PLANNING & COMMUNITY DEVELOPMENT DEPARTMENT  
Land Use Review Division

February 18, 2020 – Second Review

**RE: Sorpresa East Annexation and Development Review**  
**Files: CPC A 19-00068, CPC PUZ 19-00138, CPC PUP 19-00139**

**CONCEPT PLAN**

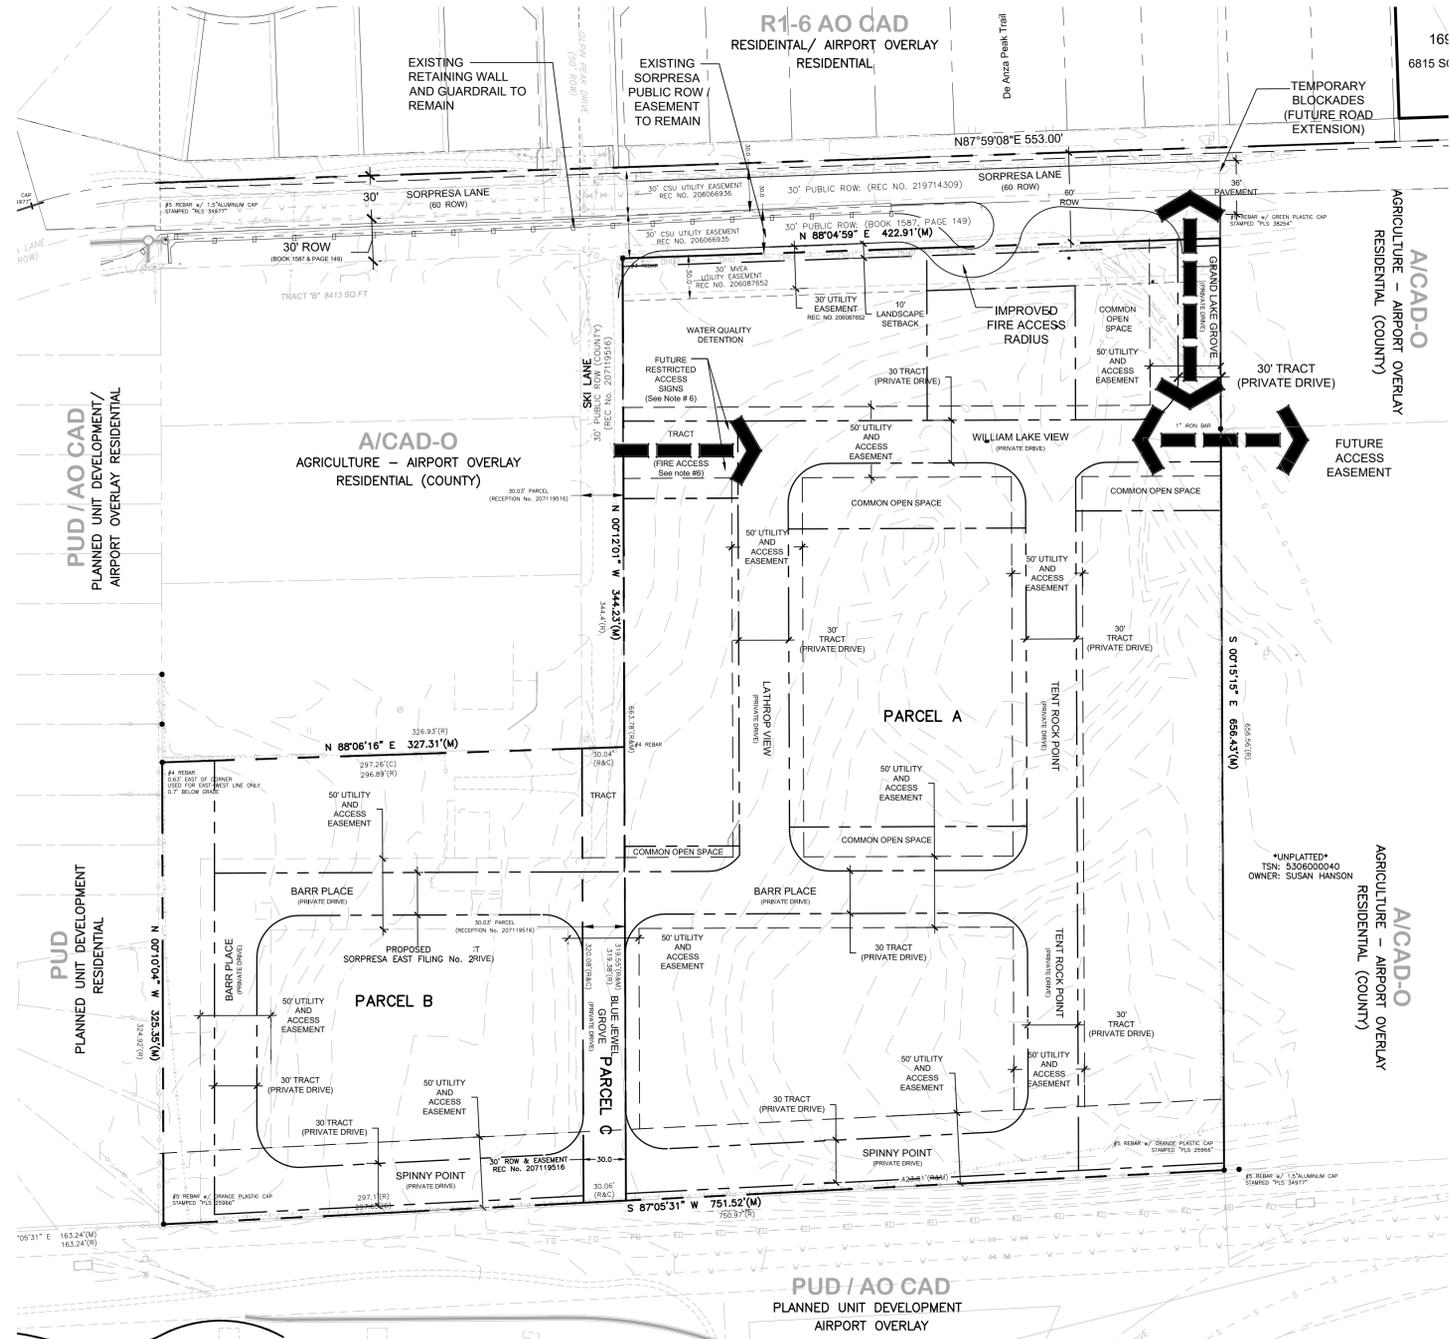
1. Show and label all ROW (City and County) and easements along Sorpresa Lane.
2. File Number – add the file number to each sheet of the plan – Not addressed

3. Site Data – add or correct the following to the site data on sheet one of the plan:
  - a. Detail a PUD zone district height/type/density note – Partially addressed, remove any CAD notation

4. Label street names (Public Safety will have another review once these are added) – Label as private streets
5. Staff understands streets are intended to all be private, the streets should be shown in tracts identified and noted as private roads. – Add to Note 2 that the private streets will be dedicated by plat for public use in addition to what you have stated for O&M

6. General Notes
  - a. Further notes on access may be needed. An agreement to be established with property owner to the east and west will be required to be recorded and agreement note should be updated with recordation information. Provide staff with a copy of this access agreement. City Planning Staff is also engaged with the City Attorney's Office to ensure the appropriate approach for the access granted.- Not addressed, should include recordation number to private access agreement that is recorded. Please also provide a copy of the recorded agreement to staff.

“NO DIRECT VEHICULAR ACCESS SHALL BE ALLOWED ONTO SKI LANE FROM THE PARCEL(S) WITHIN THIS DEVELOPMENT.” – Staff recognizes the resolution proposed with the addition of Note 5, however; please clarify how the restriction of access noted is intended to be executed. Will there be a gate/lockbox; has this been discussed with CSFD? Or is the intent for this to be managed with signs at this location and enforced by the HOA? Please update note to what will be installed at this location.

- i. In addition please modify the access arrow at this location and made a call out on the site plan referencing note 5.

1. To the north of the project area are shown open circles and darken circles which appear to be monuments that can be removed. Not addressed: To the north of the project area are shown open circles and darken circles which appear to be monuments that can be removed.
2. In regards to the note for "access easements and agreements": do the easements need to be depicted and noted on the development plan and final plat? (See Planning comment above) Partially addressed: the access agreement

to be established for the western property owners as well as the eastern property owner (General Note 1) should include the recordation number to the private access easements to be established.

1. Per recent discussions, show Sorpresa Lane with a 36' wide pavement section east of De Anza Trail.
2. Call out specific design and public improvement details along Sorpresa on the forthcoming development plan. EDR will ask for curb and gutter and 5' attached or detached sidewalks on each side of the section of Sorpresa that is to be built. In addition, the mailbox just to the west of the hairpin turn on the south of Sorpresa will have to be moved back a few feet so it is not hanging in the street.

A final Drainage Report was reviewed and returned to the engineer. Comments on the Final Drainage Report should not affect the Concept Plan. The Concept Plan is still showing the proposed water quality/detention pond being located on the west side within parcel B. Based on conversations with the applicant and responses to review comments, this pond will be removed and the entire site drained to the northern pond. The concept plan needs to be updated to reflect this change and the drainage report resubmitted. A Concept Plan requires, at a minimum, a preliminary drainage report that supports what is being proposed.

EXHIBIT "B"

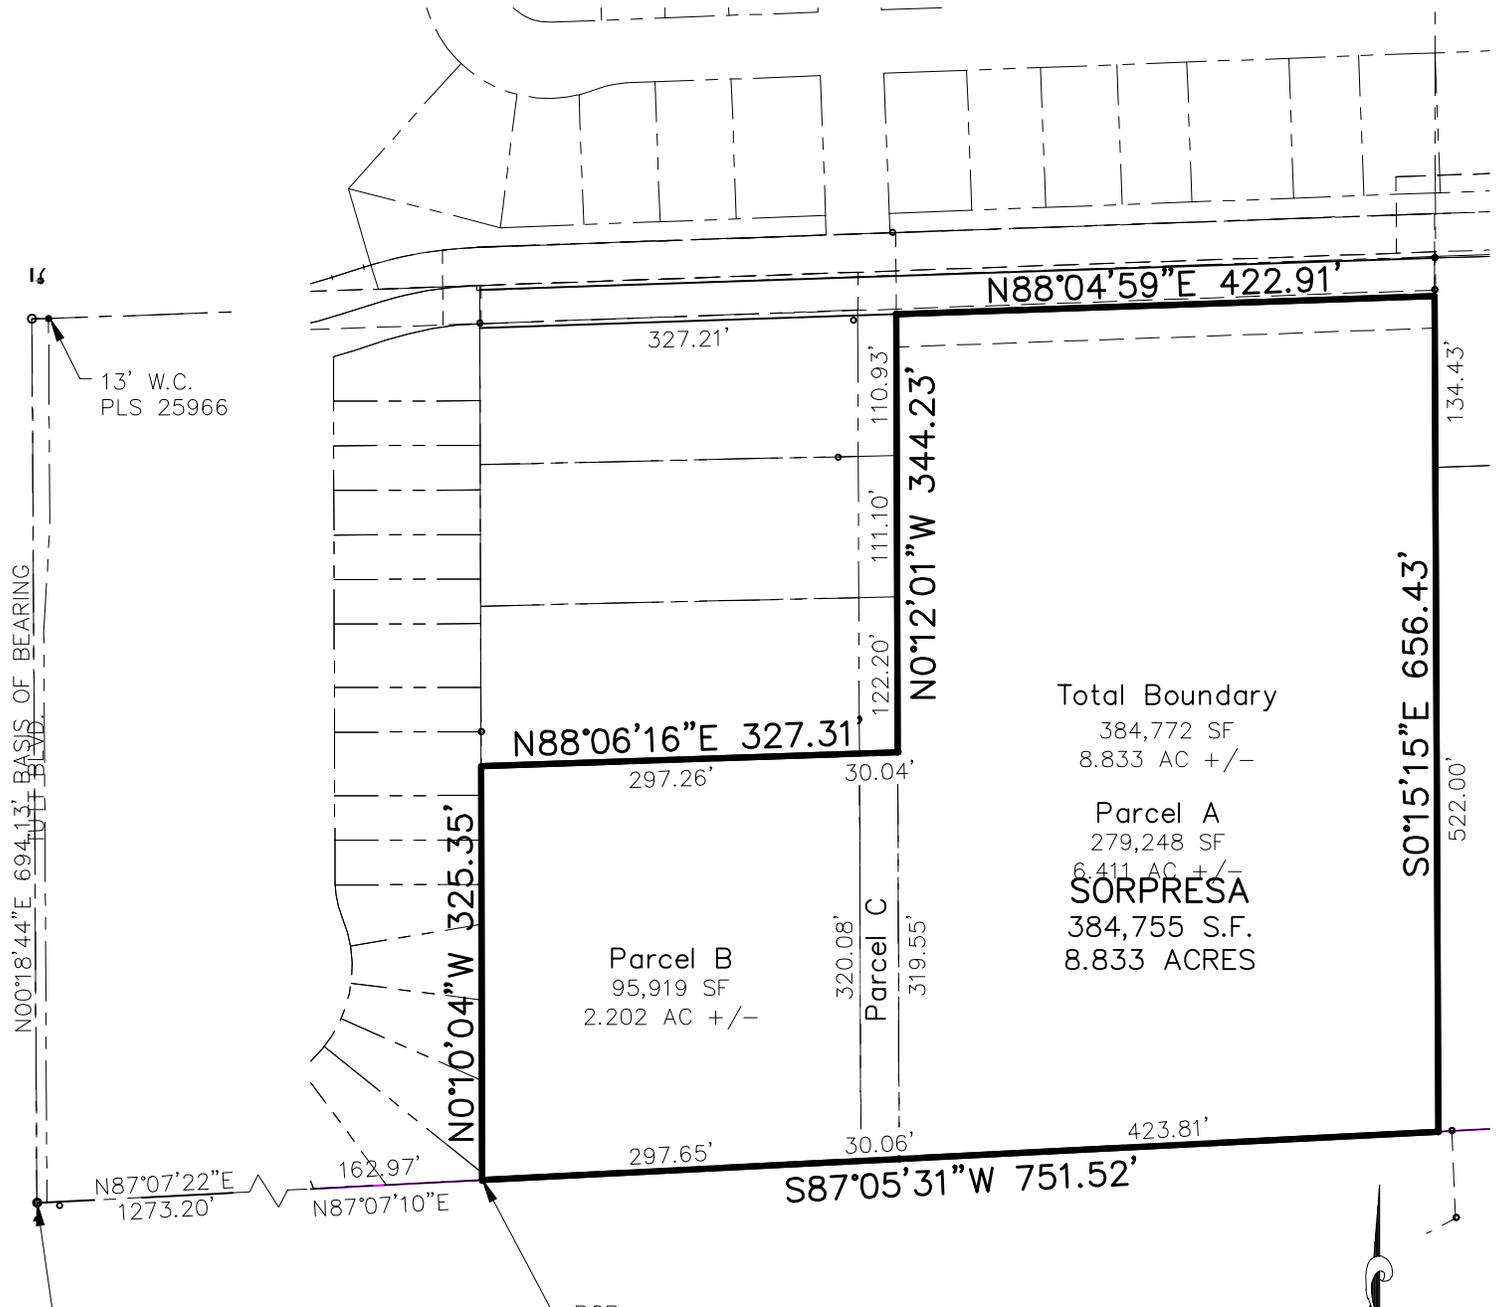
1. As a PUD zone district the height, type and density needs to be defined. As a PUD ordinance this would read as (ex.) Planned Unit Development (PUD); single-family detached, xx DU/AC, 35-foot maximum height with Airport Overlay. Please clarify density so this can be included in zoning.
  - a. Add zoning description, Planned Unit Development (PUD); etc. to this exhibit. – Partially addressed, please remove anything with CAD; this should only read as PUD-AO
